**OXFORDSHIRE COUNTY COUNCIL’S RESPONSE TO CONSULTATION
ON THE FOLLOWING DEVELOPMENT PROPOSAL**

Application no: 22/01488/OUT

Proposal: Construction of up to 140,000 sq m of employment floorspace (use class B8 with ancillary offices and facilities) and servicing and infrastructure including new site accesses, internal roads and footpaths, landscaping including earthworks to create development platforms and bunds, drainage features and other associated works including demolition of the existing farmhouse

Transport Schedule

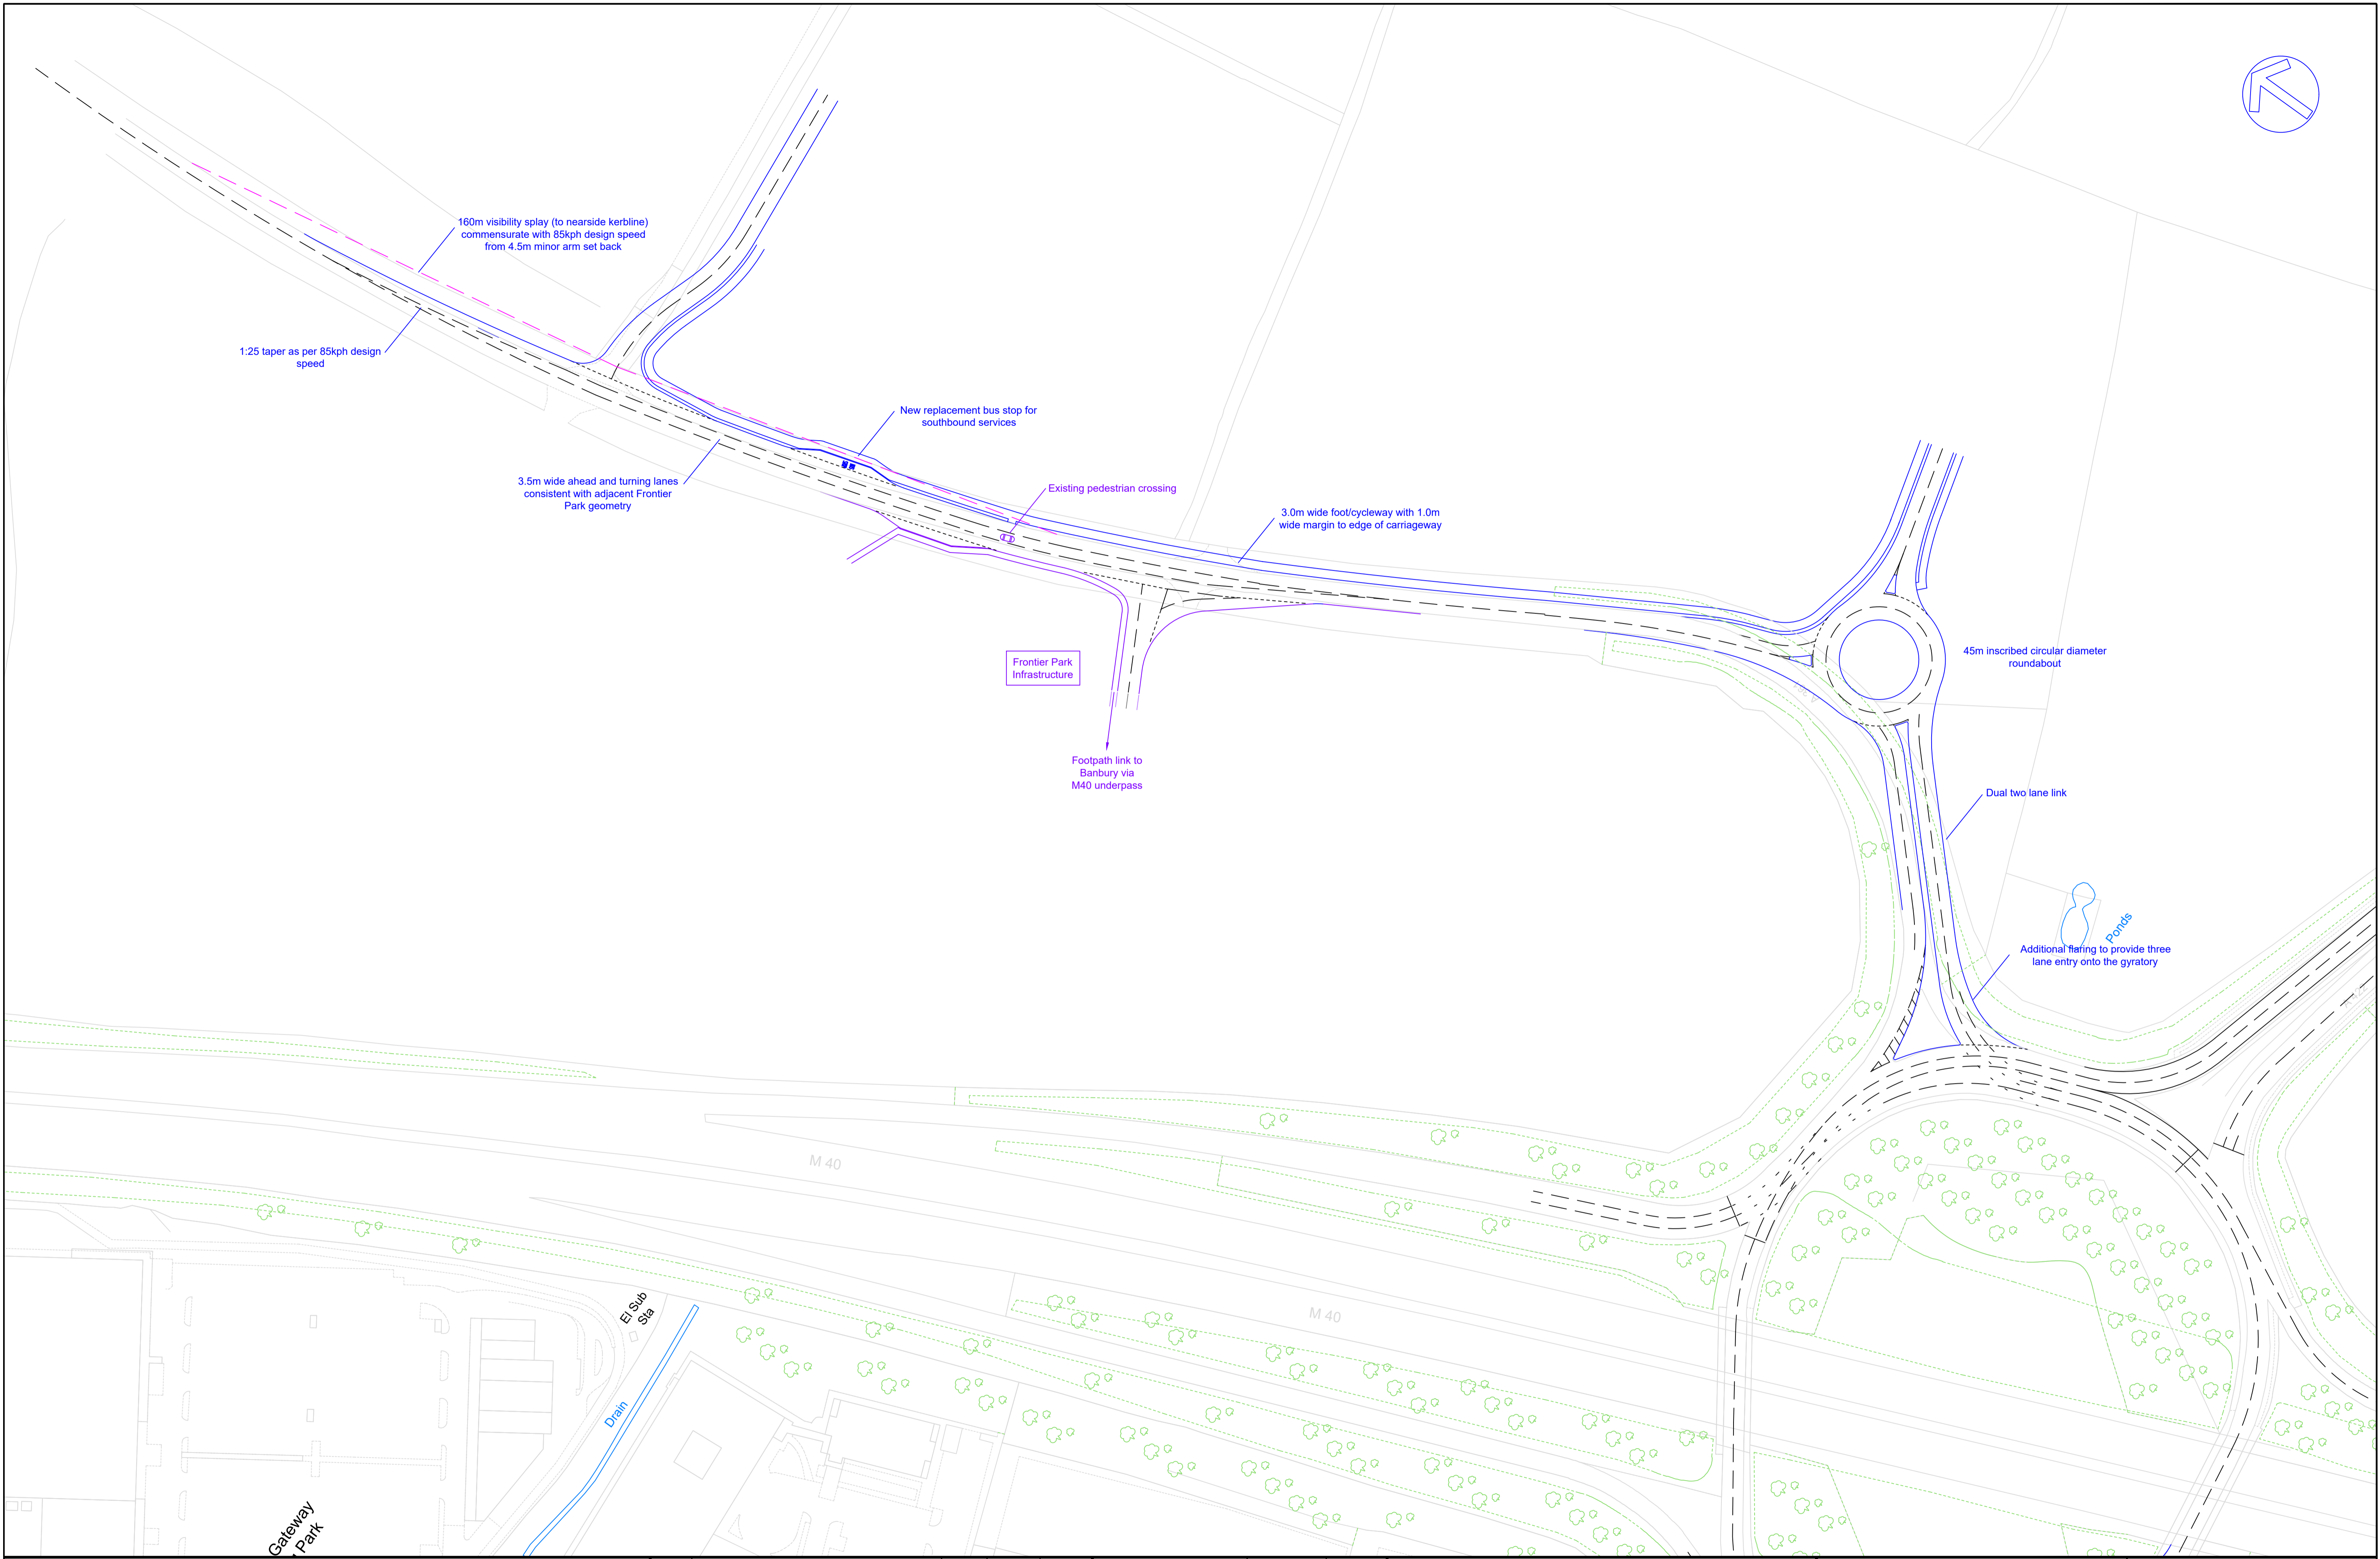
Cyclists heading to the northern warehouse in Frontier Park will be able to access it directly from the cycle track, so will not need to use the road at all. Those heading for the southern warehouse will be on-road for about 190m before gaining access to the car park at the service yard junction. None of these cyclists will encounter turning vehicles.

It is different and more onerous for cyclists heading to the development site. Whilst on-road they will pass the southern warehouse car park access junction and, potentially, the access junction to the mixed-use development (undecided application no. 21/02467/F). The latter will generate many vehicle turning movements at this access and at the A361 junction. Cyclists will have to cross the A361 but the route into the development site is not yet defined. A toucan crossing and appropriate lengths of cycle track on either side of the A361 may be required to facilitate a safe crossing point.

It is not disputed that the site boundary adjoins the highway boundary so that any highway widening could use land within the site. However, there is a significant level difference between the carriageway and the ground which will present a considerable technical challenge, and it has still not been demonstrated that these proposed highway modifications are feasible.
